Subject: Palomino V Review

In reviewing Palomino V, the only issue I see is the cul-de-sac in Tract D-1. In prior review comments, I addressed a missing note detail about this cul-de-sac, which you have removed.

**LCU, INC.**  
Surveyed by LMH Scale 1" = 300'  
Drawn by Tml/FCS Sheet 1 of 4  
Checked by FCS Project No. 18146

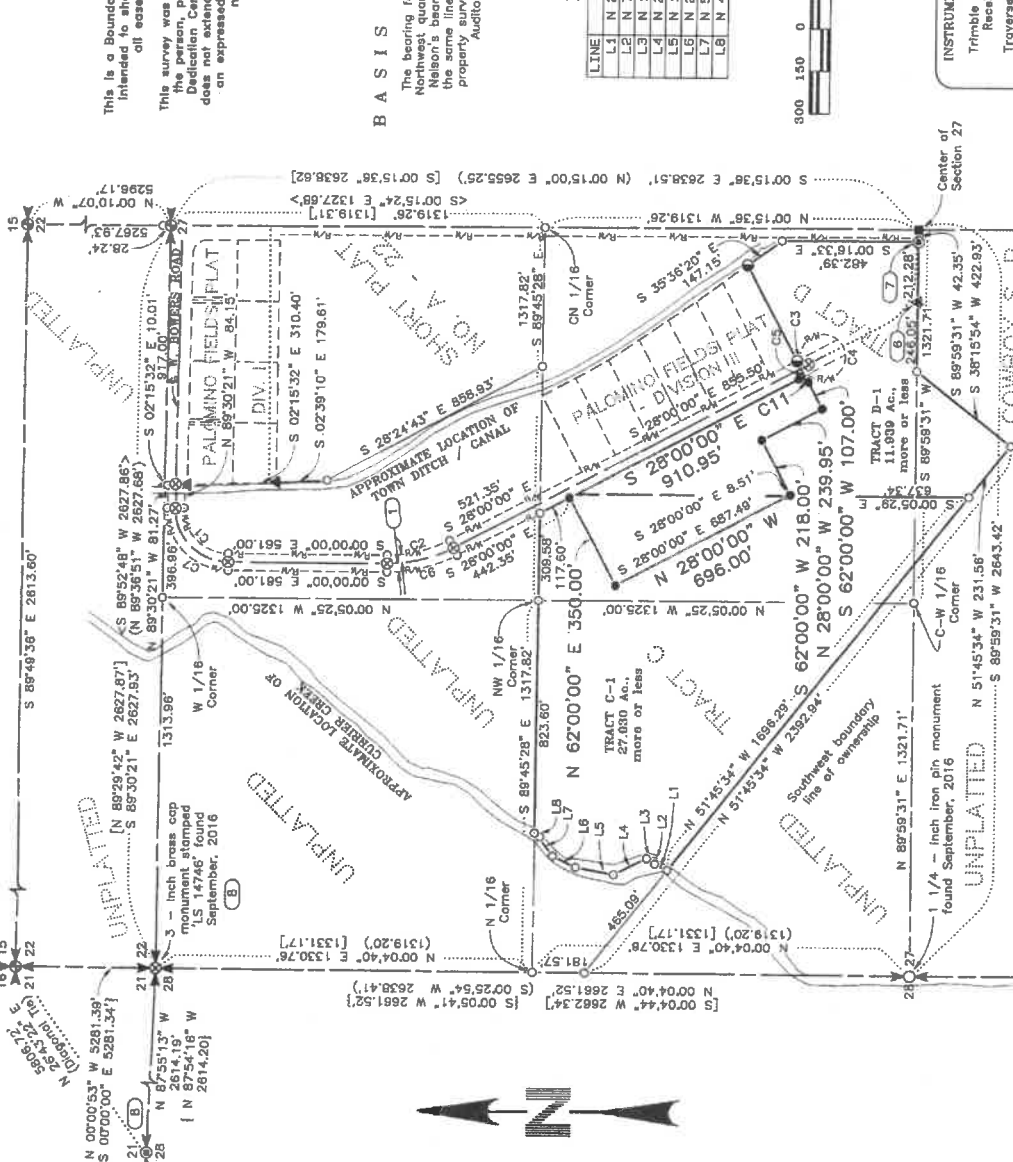
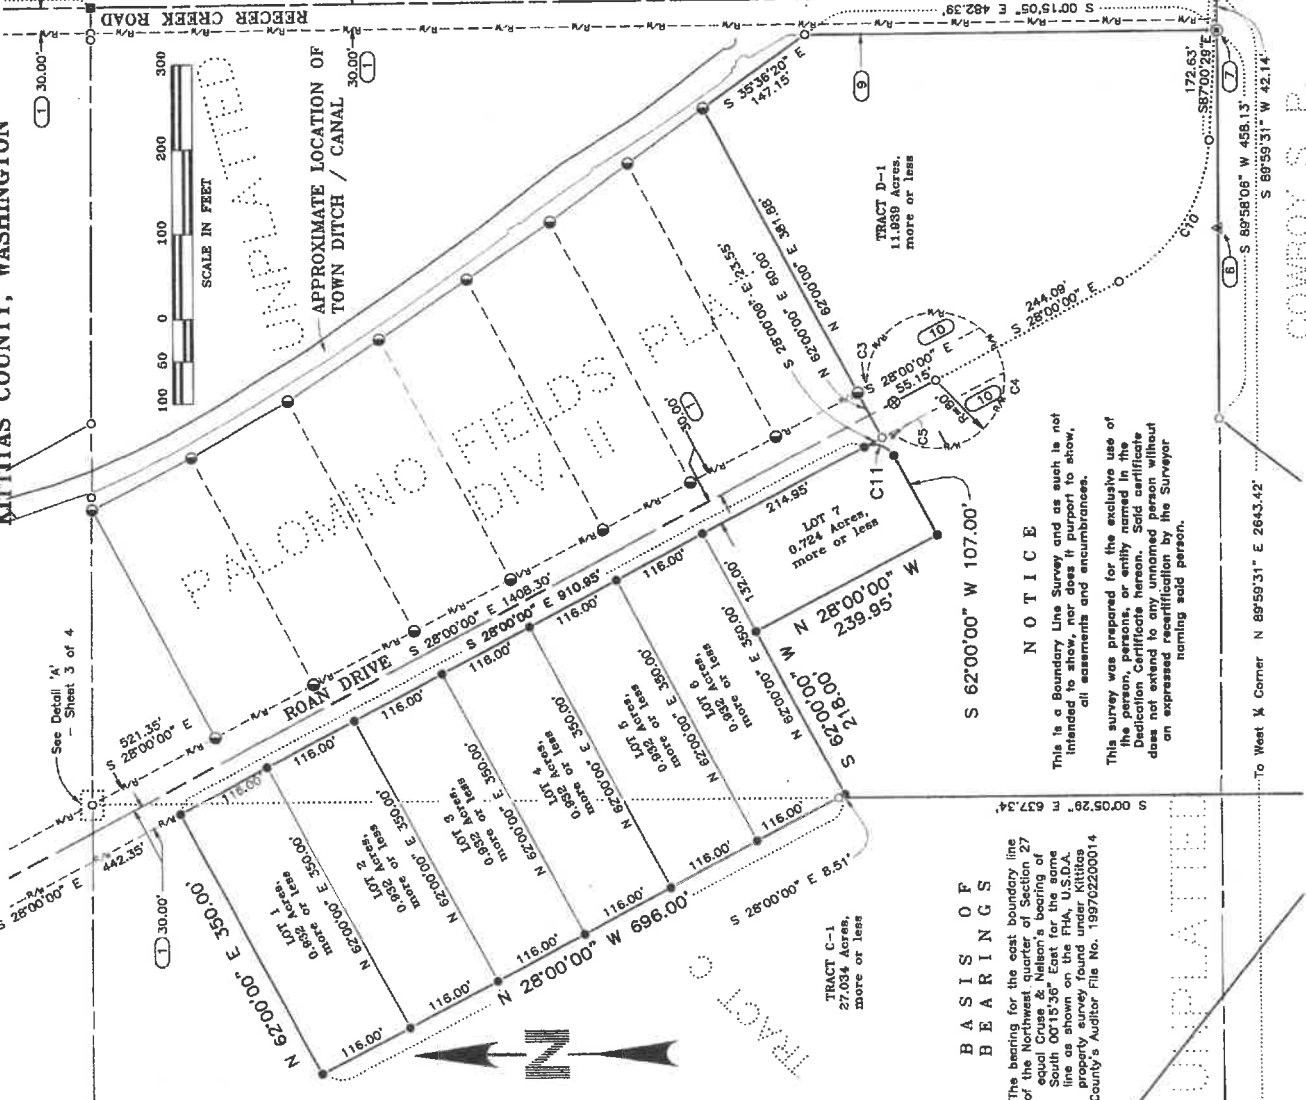
The issue is the line type calls out the Cul-de-Sac as right of way rather than an easement.

As these issues were addressed during Palomino II, I am fine with not having any note at all, and just removing the R/W from the dashed linework. You (or your representative) could easily swap out the front page, or carefully scratch off the letters with a blade.

Alternatively, (and I believe this to be less desirable) is the land identified as easement in Palomino 2 is now deeded as right of way, the area removed from Tract D-1, and subsequent vacation of the right of way would then require commissioners approval.
